Appeal Decision

Appeal Ref: APP/R5510/W/21/3281152

Grass verge on Swakeleys Road, Ickenham, Uxbridge UB10 8DP

Title: 265 MAXIMUM CONFIGURATION
SITE ELEVATION

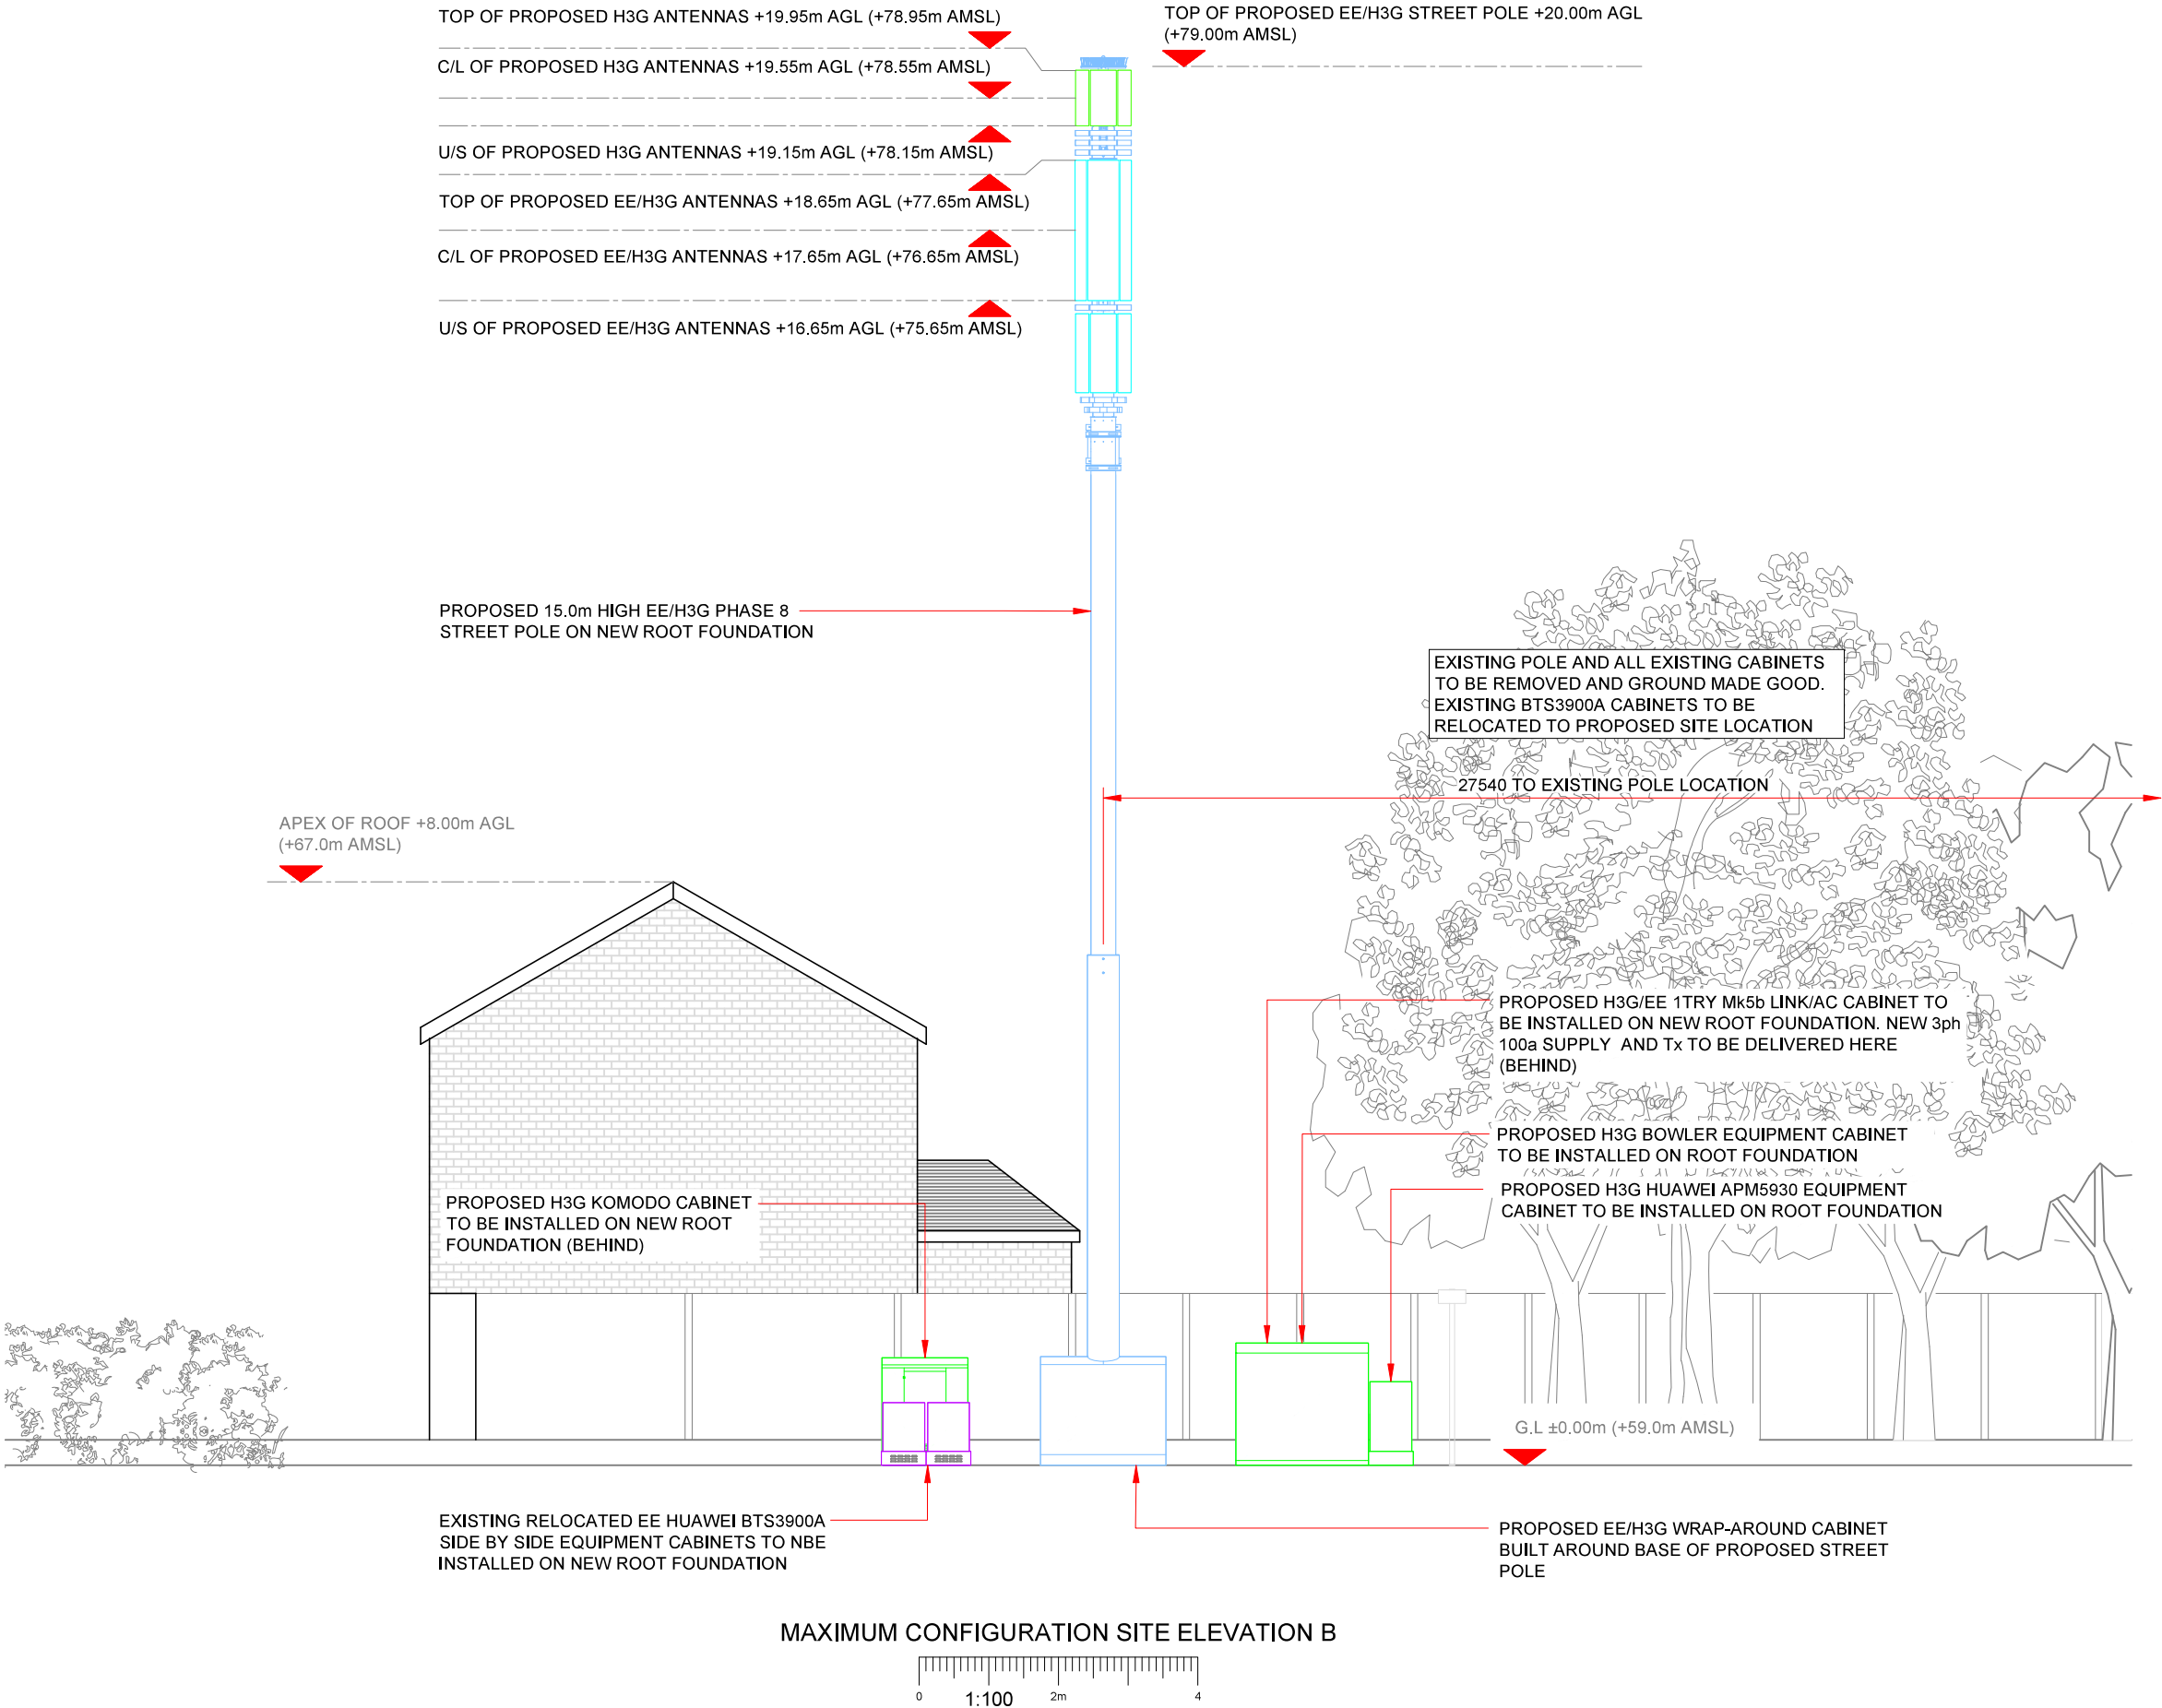
7. There is mature planting evident within the surrounding area and close to the appeal site. The proposed monopole would however rise above the heights of the adjacent tree belt. Despite the tree coverage, the addition of a tall, unshrouded monopole in this undeveloped corner location would not be sufficiently screened from view from both short and longer distance public views along the public footpath and main roads. This is even with the curve of the road and local road network layouts, and despite the fact that it is a heavily trafficked transport route. Irrespective that the appellant states it would be finished grey in colour, it would appear incongruous in this location as an uncharacteristically high and stark feature that would not successfully blend into its environment.

11. Although the existing monopole and its cabinets would be removed, overall, the proposed monopole here would appear as an alien, standalone and visually obtrusive feature in this location. It would detract from the pleasant leafy environment and would adversely harm the character and appearance of the local area.
